CITY OF ALBUQUERQUE

July 12, 2012

Re: Tuscan Village Rough Grading Plan
Engineer's Stamp Dated 6-20-12 (E22/D022)

GRADING PLAN (PHASE 1)

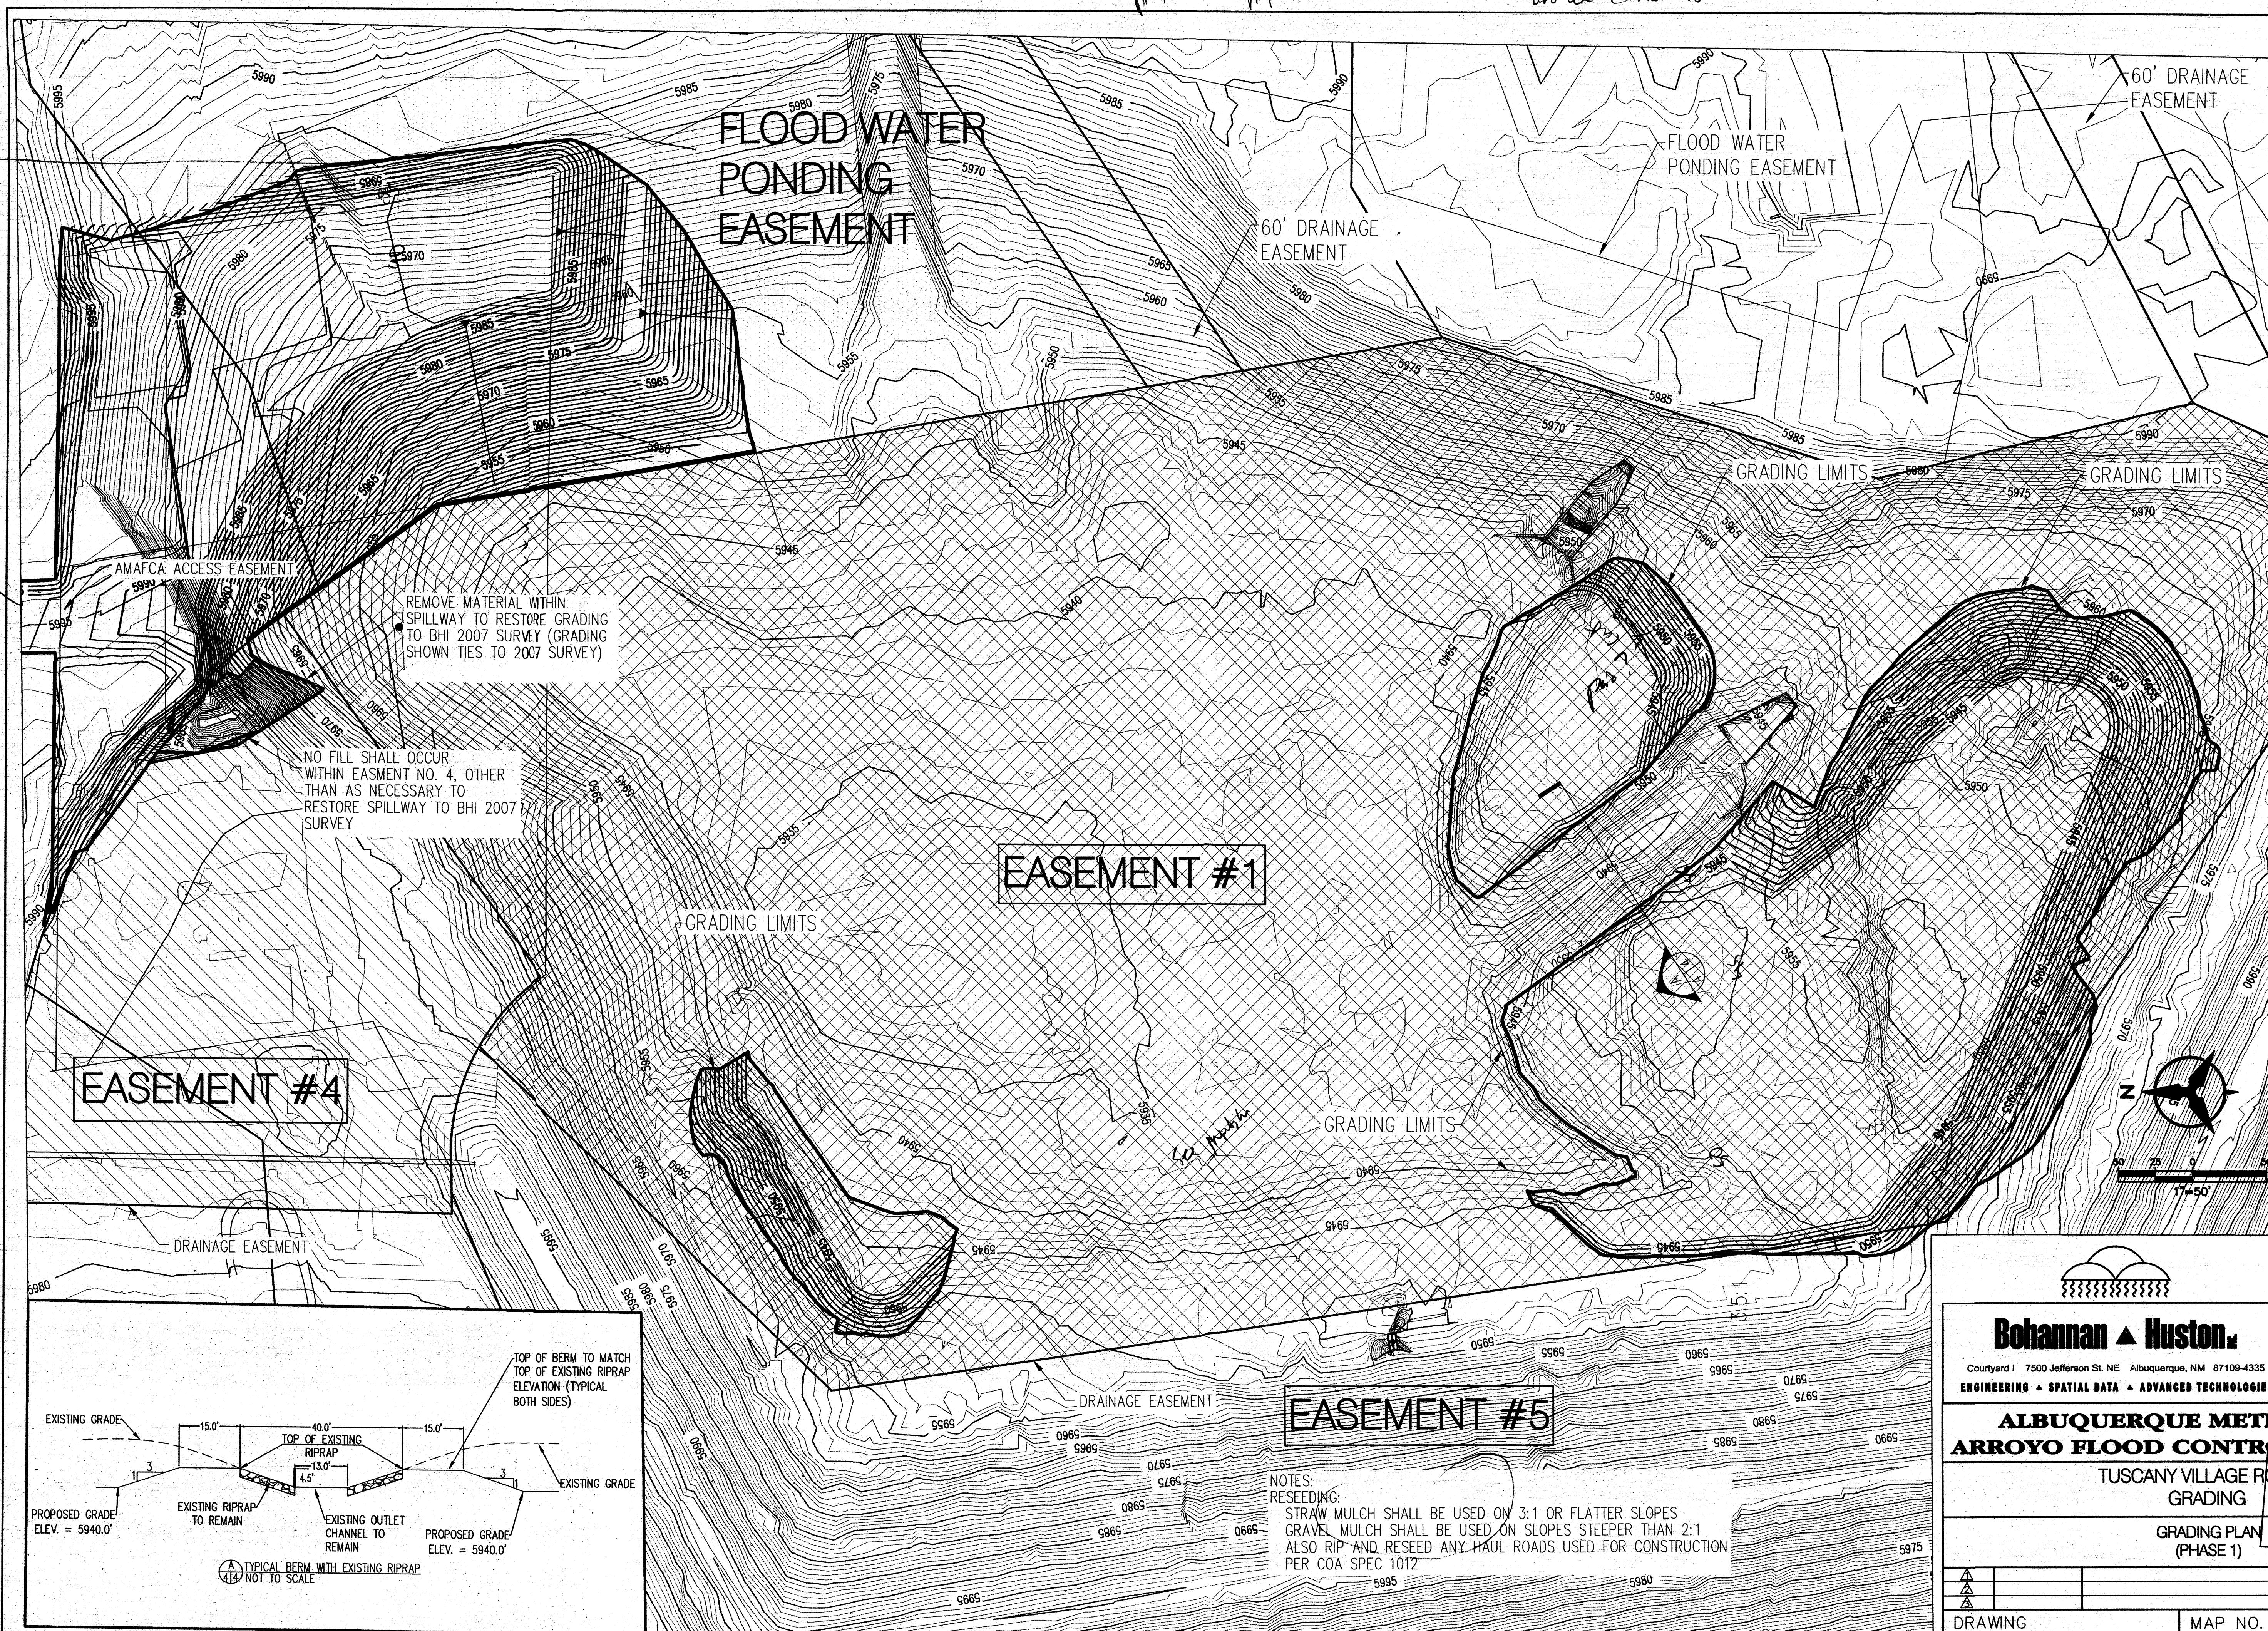
- Provide property lines on the grading plan.
- The engineer for the owner of Lot N3A went on record at DRB to inform Hydrology that this project has encroached onto his property in excess of an agreement (Grading and Improvement Agreement?). If proposed grades extend into Lot N3A, approval from the owner of Lot N3A is required.
- Provide easement information.
- Grading plan extents should extend north to San Antonio Dr.
- Provide a detail of the spillway area and BHI 2007 survey as referenced on this plan. Where is the dam spillway and what is its elevation?
- Reseeding notes do not provide an erosion control for slopes between 2:1 and 3:1. An engineered means of erosion control is required for slopes steeper than 3:1.
- Since Phase 2 was provided for information only, it was not reviewed and comments in this letter apply to Phase 1 only.
